From: Amber Willard
Sent: 28 January 2019 09:28
To: Karen Parsons
Subject: FW: 1 Church Farm Cottage, Yapton.

I am currently writing up Y/81/18/HH for the loft conversion and dormers however on looking at the plans I believe the elevation may be incorrect. On the block plan/ location plan (171164/06) the dormers are shown facing the northern elevation with Velux windows to the south. Whereas on the plans and elevations as proposed (171164/02) the dormers are to the southern elevation and velux to the north.

UNIT 2
Location and Block
Plans

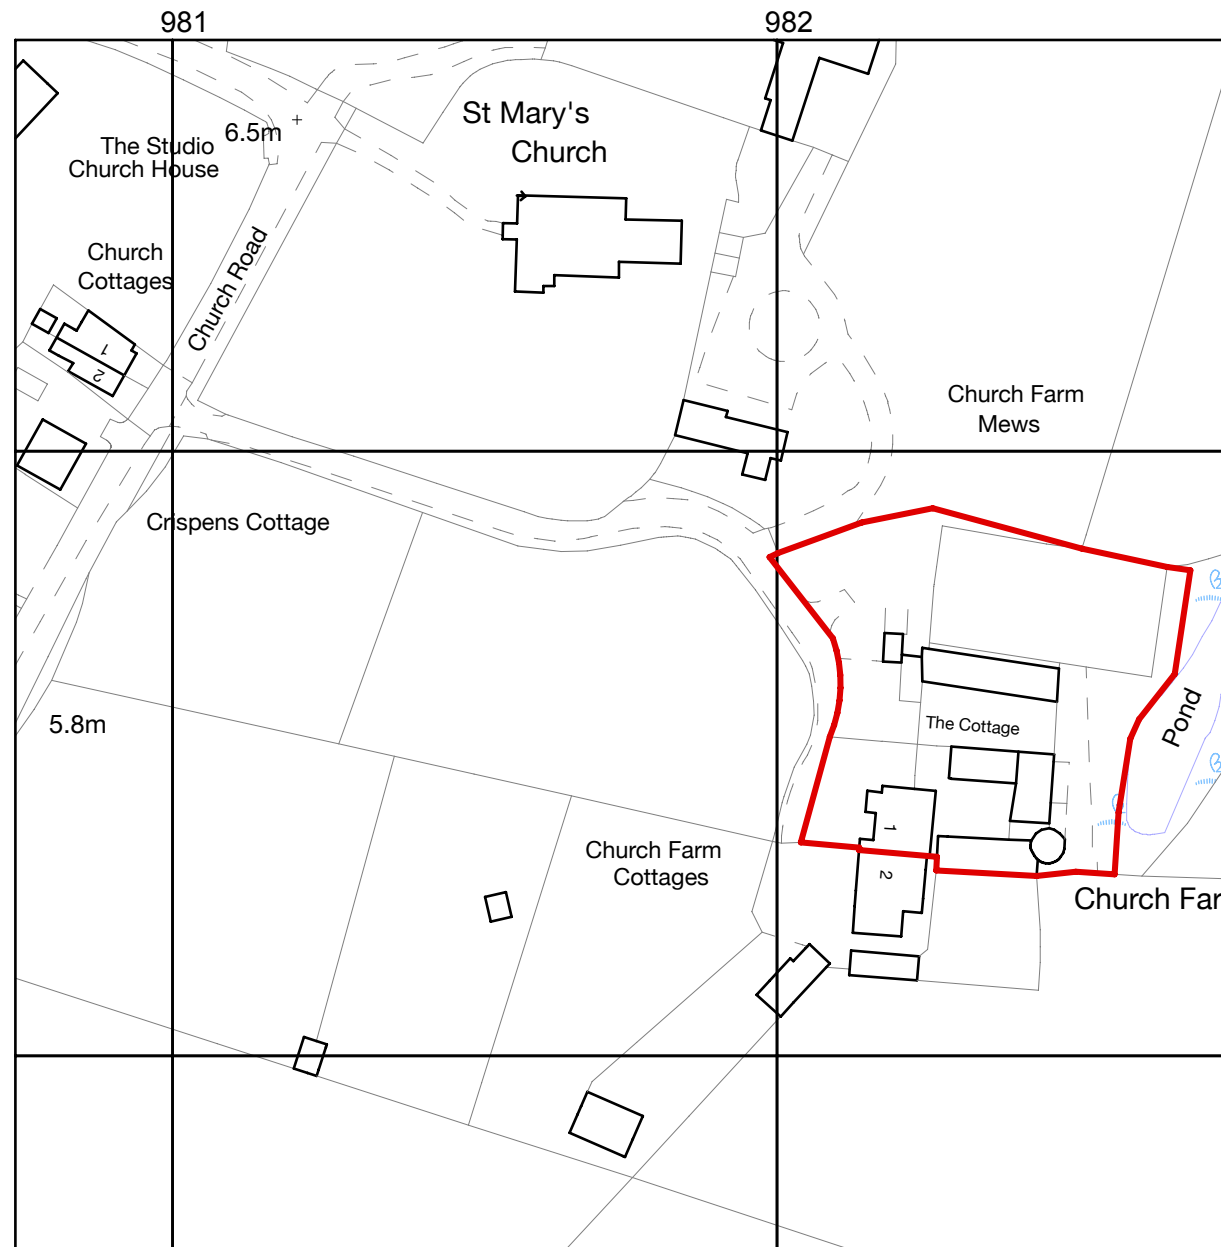
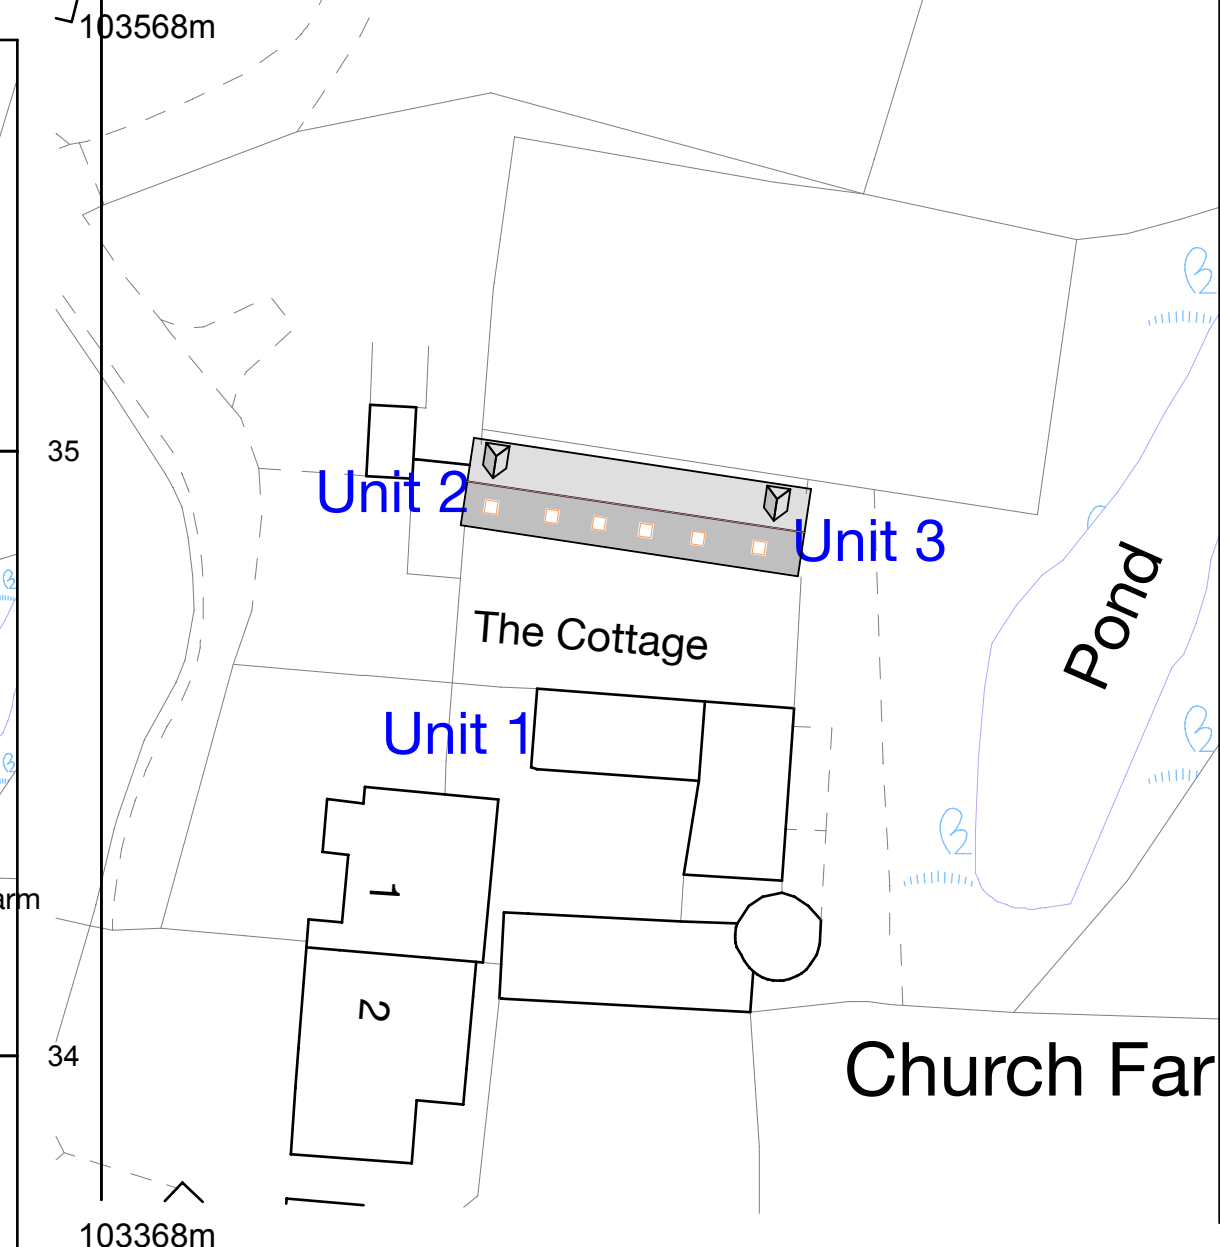
Please can you confirm which elevation the dormers are and amend the plan as necessary.
